INTERESTED PARTY NUMBER: [REDACTED]
APPENDIX 2: RESPONSE TO CHANGE 1: HOVERPORT

Submitted by David Stevens, physicist

Change 1 – Access to the hoverport near Cliffsend, Kent.

Title
THE NATIONAL GRID (SEA LINK) ORDER
INDICATIVE GENERAL ARRANGEMENT PLANS - KENT
PINS APPLICATION NUMBER: EN020026
REGULATION 5(2)(o)
SHEET 3 OF 6

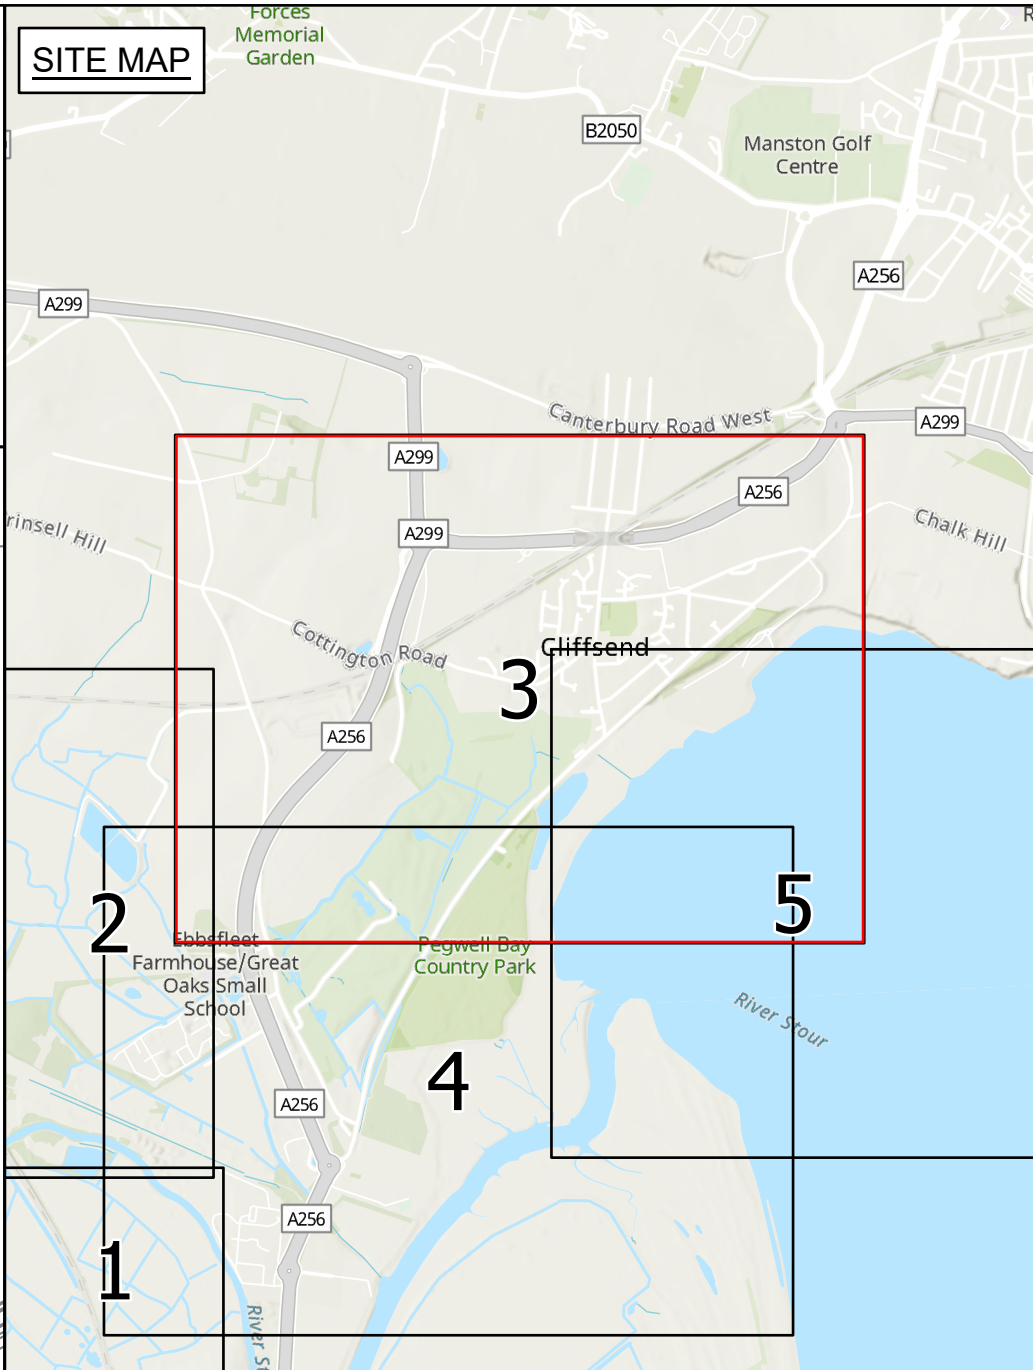
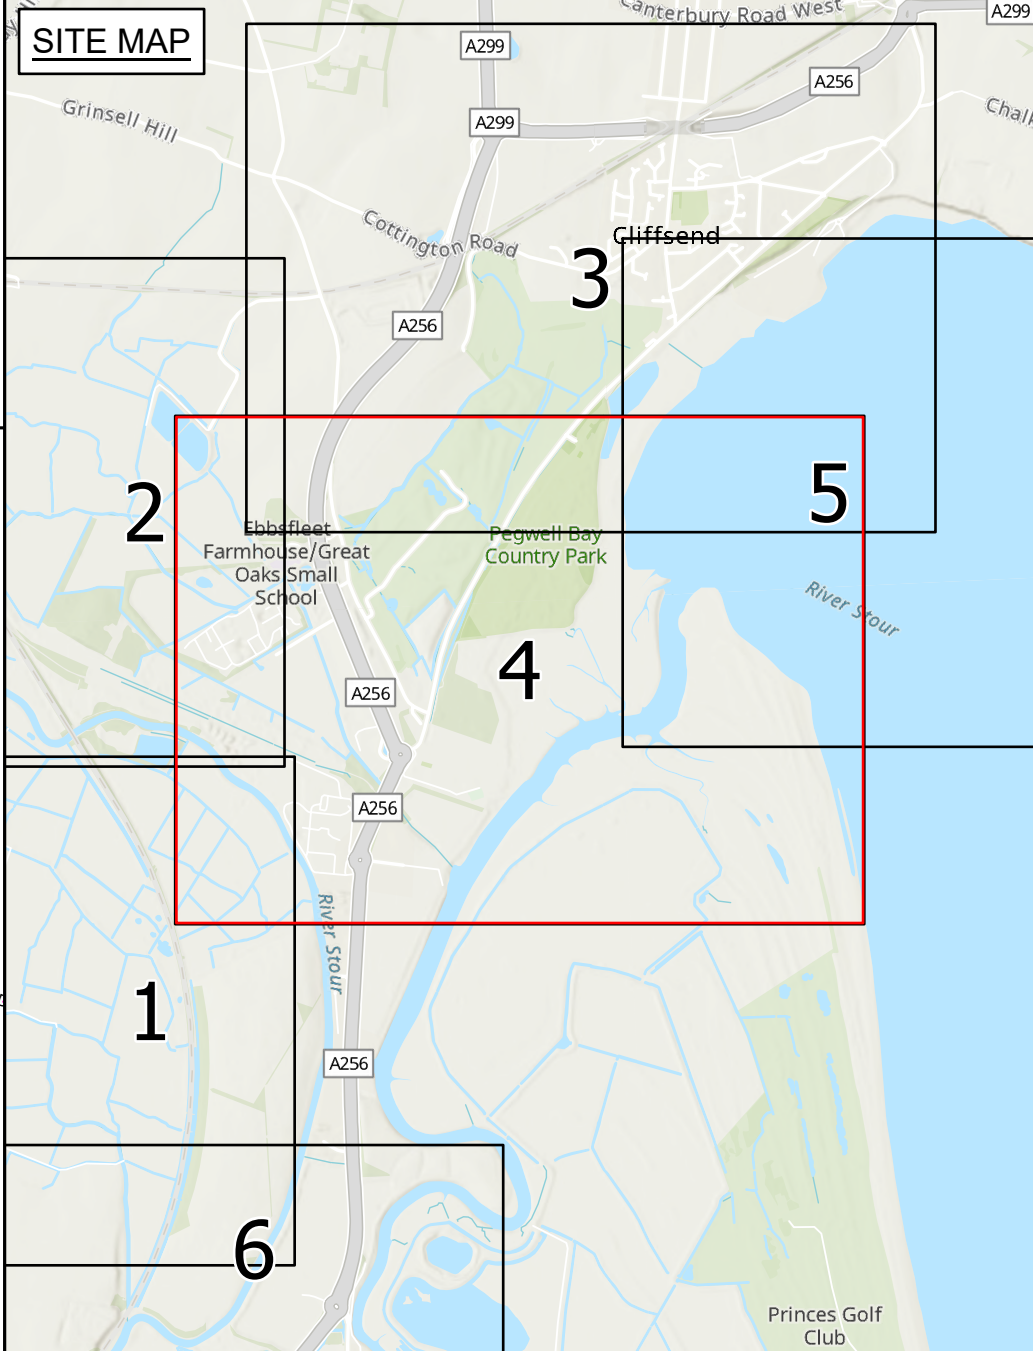
Unfortunately, the amended plans had an access point to the intertidal area from the hoverport apron that passed through existing saltmarsh. Again, this calls into question the priority NG give to safeguarding habitats when making important decisions.

The change to the access asked for would result in a much larger area of the apron being set aside which is contrary to the Mitigation requirements in the NPS EN1.

The applicant is very vague and as this is a popular and valued site for residents to enjoy the flora and fauna, there is a potential health and safety risk with the lack of certainty over the areas being used for the project and the areas that are safe for them to use.

Subsequent plans in November 2024 showed the compound being removed from the hoverport completely, presumably because of the presence of rare invertebrates and orchids, but the order limits shown in the plans included the area previously allocated for the compound. The order limits in Change 1 include most of the apron including the area that had previously been allocated as a compound.
